Consultation Response from KC, Highways Development Management

2021/93567 Land off Westgate, Cleckheaton, BD19 5DR

Erection of 180 dwellings with associated works

Date Responded: 28/03/23

Planning Ref:	N/A
Drawing Number:	18-CL2-SEGB-WE-01
Revision:	P

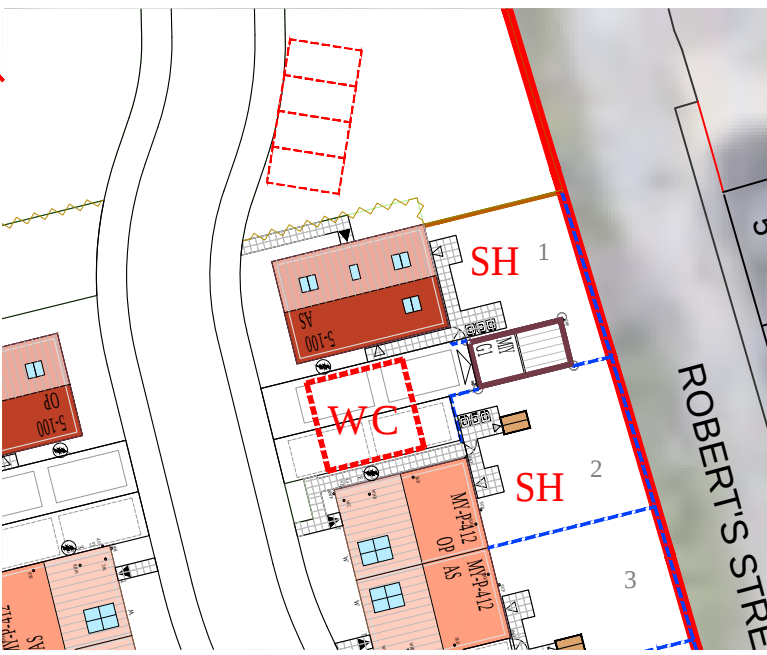
This is a full Planning Application for the development of residential dwellings on land to the south of Westgate, Cleckheaton (Planning Layout Drawing 18-CL2-SEGB-WE-01 Rev H now includes 180 dwellings).

The proposed site layout has been amended significantly through the course of the application. This has resulted in a much improved layout, which is considered to be suitable for adoption (subject to a full technical review at the S38 detailed design stage). A summary of some of the key features within the site layout are as follows:

- The site layout includes a single point of access on to Westgate. However, following the initial section of access road, a loop road system is then formed, which has eliminated a number of unnecessary cul-de-sacs that had originally been proposed. This has significantly improved the site layout and is welcomed.
- All of the main roads within the site are proposed at 5.5m wide, with 2m footways generally provided on both sides. Additional 2m wide verges are also proposed in places, allowing for some street trees to be provided within the site.
- 2.4x25m visibility splays have been provided at all internal junctions. Raised tables have been proposed at all junctions, to encourage slow traffic speeds.
- 2 No. speed bends have been proposed within the site. At these speed bends, forward visibility of 17m has been demonstrated. This is below the 25m that is normally required for a 20mph

design speed (17m SSD is suitable for a 15mph design speed). Therefore, to mitigate this, raised tables have been proposed at the speed bends to again encourage low traffic speeds.

- 26 No. visitor parking laybys have been provided within the adoptable estate roads. In addition to the formal visitor parking laybys, other opportunities are available to safely park on the proposed estate roads, as well as 3 No. visitor bays proposed within the shared private drives, which should provide adequate visitor parking provision for the development. To demonstrate this, the applicant has provided swept path analysis to confirm that at least 45 visitor cars (e.g. 1:4 units, in accordance with the Kirklees Highway Design Guide) can safely park within the site without causing obstruction to the Councils refuse vehicle.
